AGREEMENT TO CONSTRUCT  
SUBDIVISION IMPROVEMENTS

WHEREAS, the Developer is developing certain lands within the City of Albuquerque, County of Bernalillo, State of New Mexico known as Summit Hills (hereinafter referred to as the "Subdivision"); and

PUBLIC INFRASTRUCTURES  
FOR  
TRACT A-1, SUMMIT HILLS SUBDIVISION  
DRB #85-327  
JULY 29, 1985

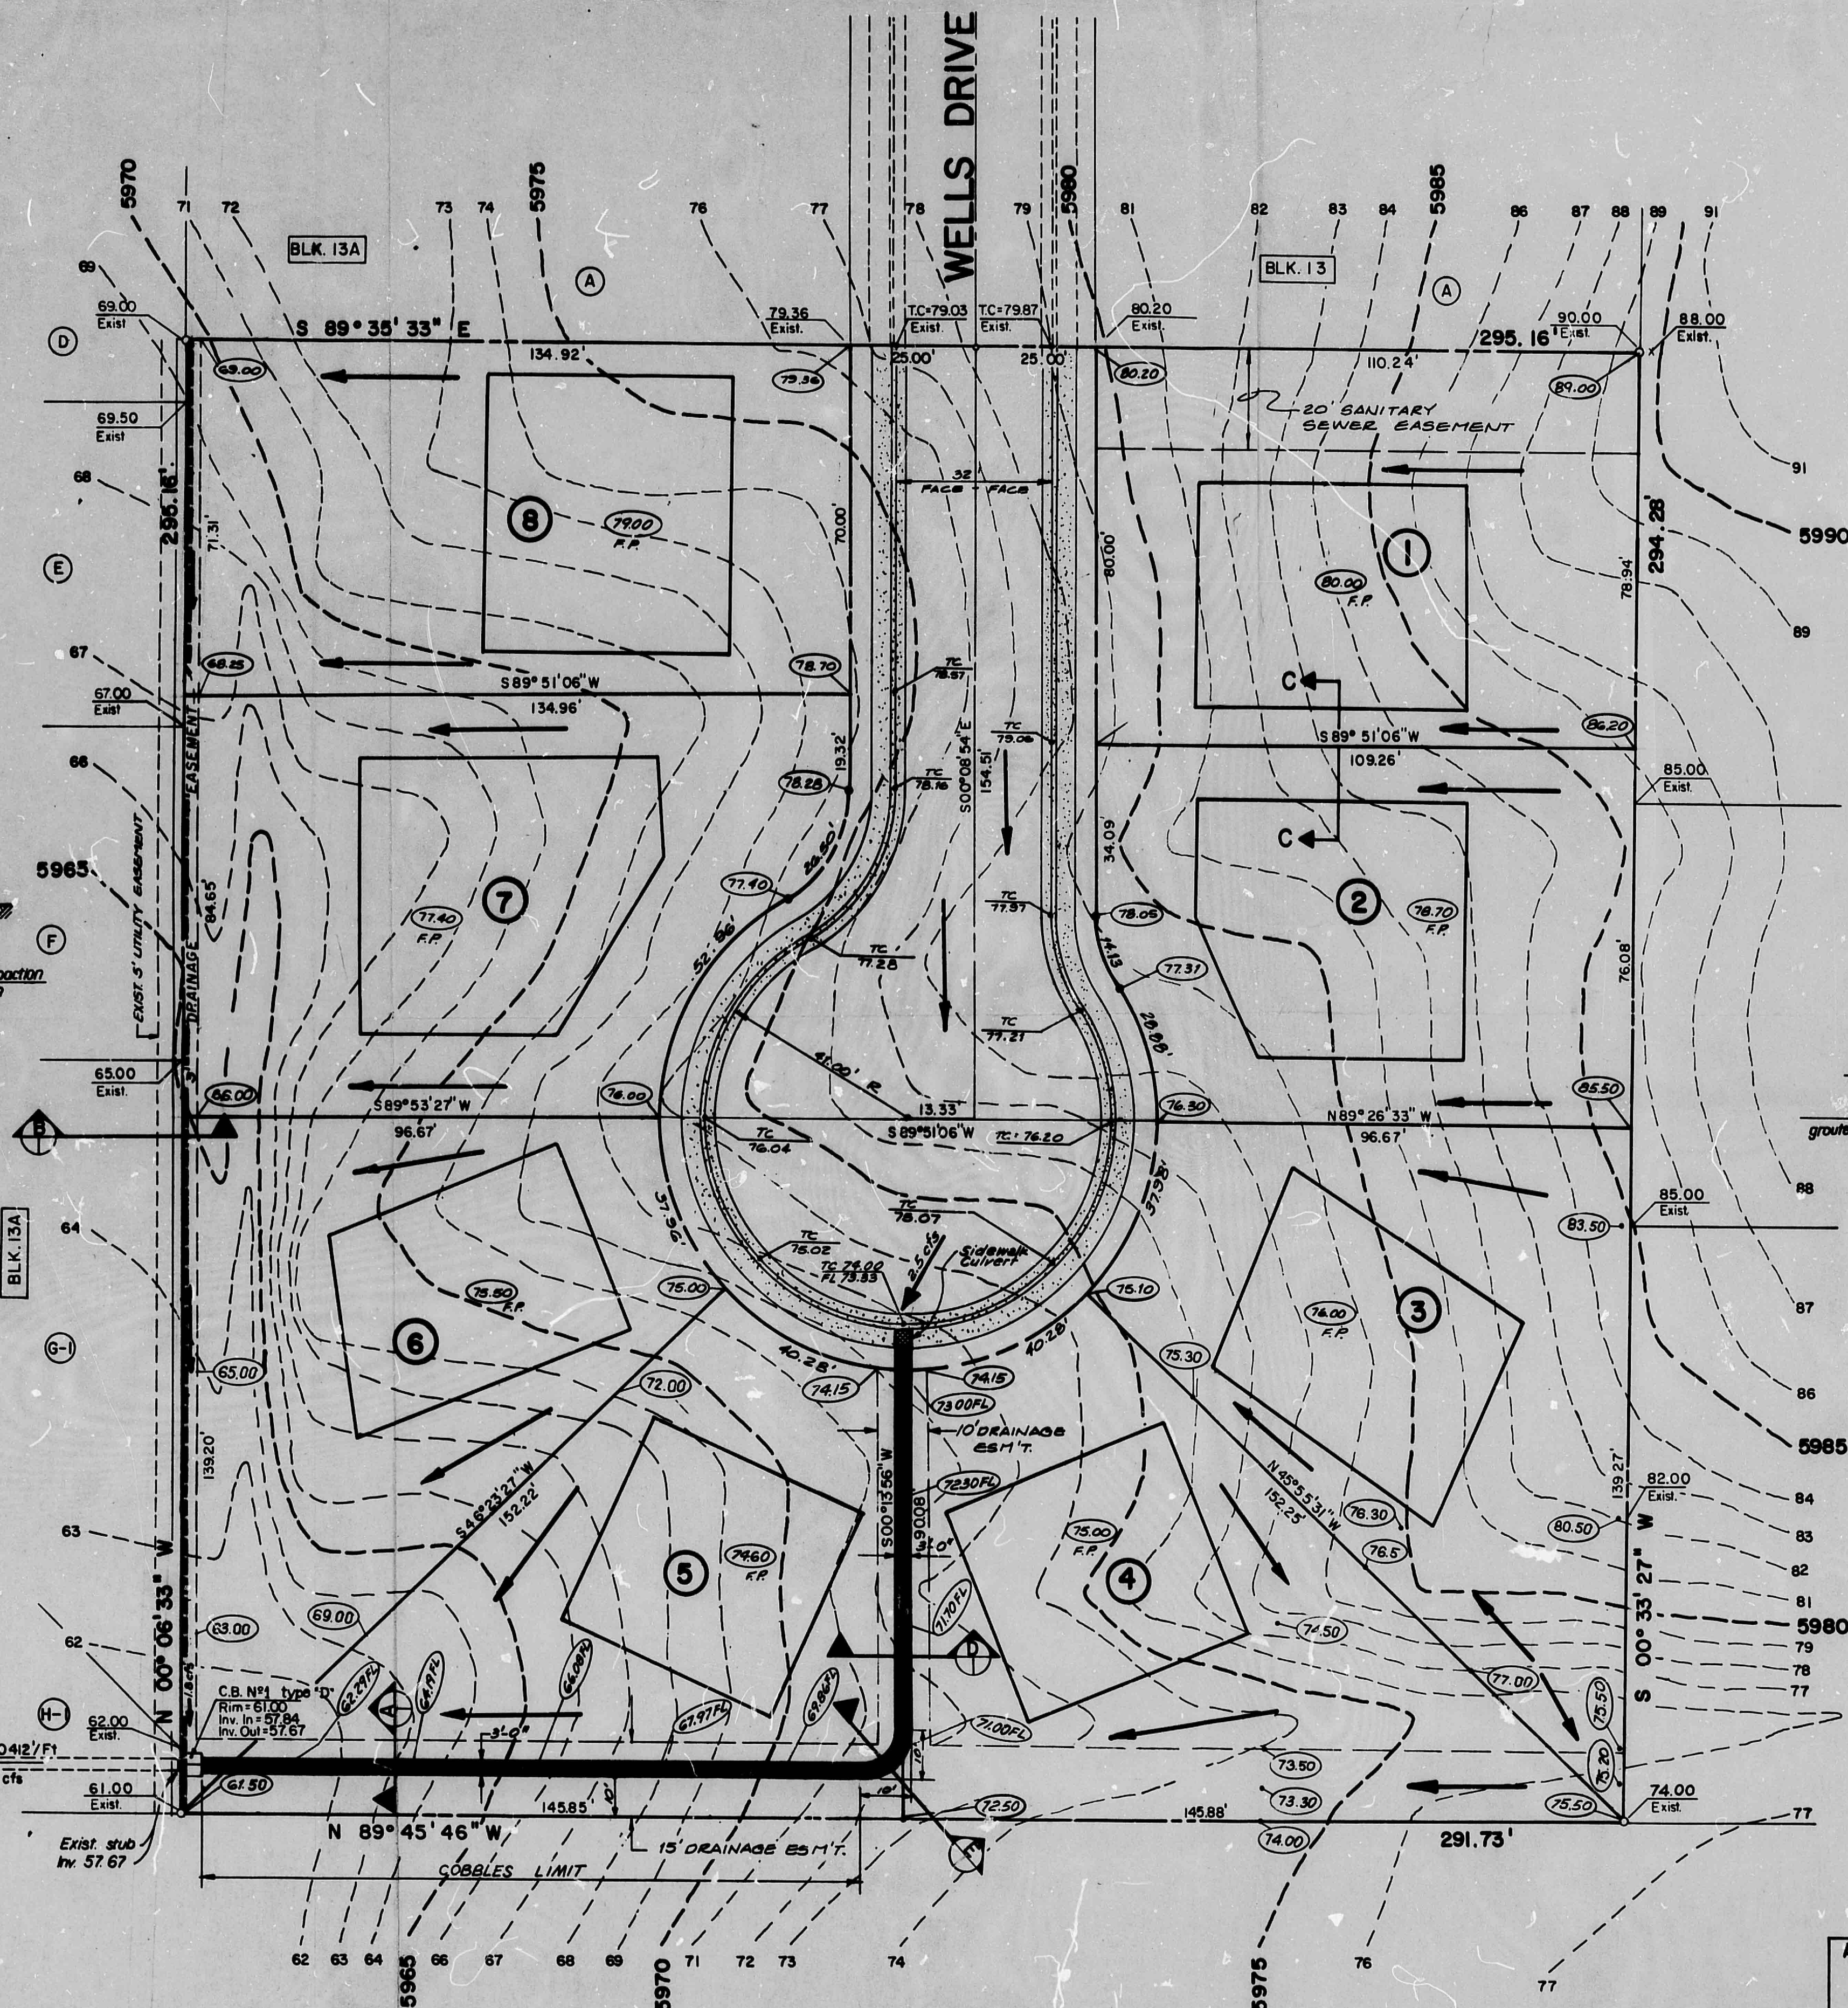
1. Please submit the approved work order drawing which shows the 18 inch RCP from the rundown to catch basin number one (1). Indicate the work order number on the drainage plan.

2. Please show grades on the developing property to the east. Show how your property interfaces with this site.
3. Please show more proposed spot elevations on the lots. Especially address lots 3 & 4.

6. Reducing the developed flows below the existing flows does not relieve the engineer of checking downstream capacity. Please check the capacity of flows at Verbena Place and Snowdrop. We have been receiving complaints on this particular corner.

1. The 18" RCP was constructed under Change Order No. 2 for Project No. 2176.
2. Grades indicated on the plan are proposed for the developing adjacent properties.
3. Additional spots have been added to the plan.
4. An extra copy is enclosed.
5. The calculations have been reviewed and revised.
6. We have determined that there is no downstream capacity. However, the enclosed calculations show that this is an existing problem. Prior to the construction of Summit Hills, the flow at the analysis point was approximately 42 cfs. This resulted in a depth of 1.0 feet for the 100-year flow at the analysis point. Construction in the area has reduced the flow to 16.6 cfs and the depth to 0.66 feet. We propose to discharge an additional 4.3 cfs which will only increase the depth of the 100-year flow by 0.04 feet as shown in the calculations.

### SECTION D & A

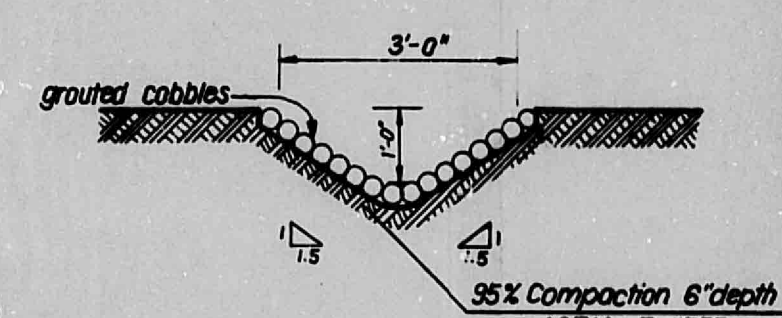
4. The use of the unlined channel shown on Section A is not a standard City section. We will be required to maintain this channel. Please submit two copies of your drainage plan for your next submittal. We will request Dan Hogan to review this channel for his concurrence.

5. The calculations on page 3 show a 6 to 1 side slope and a 0.0267 invert slope. Please review this design with the drainage plan and Section A. Review the velocity of the channel for erosion possibilities.
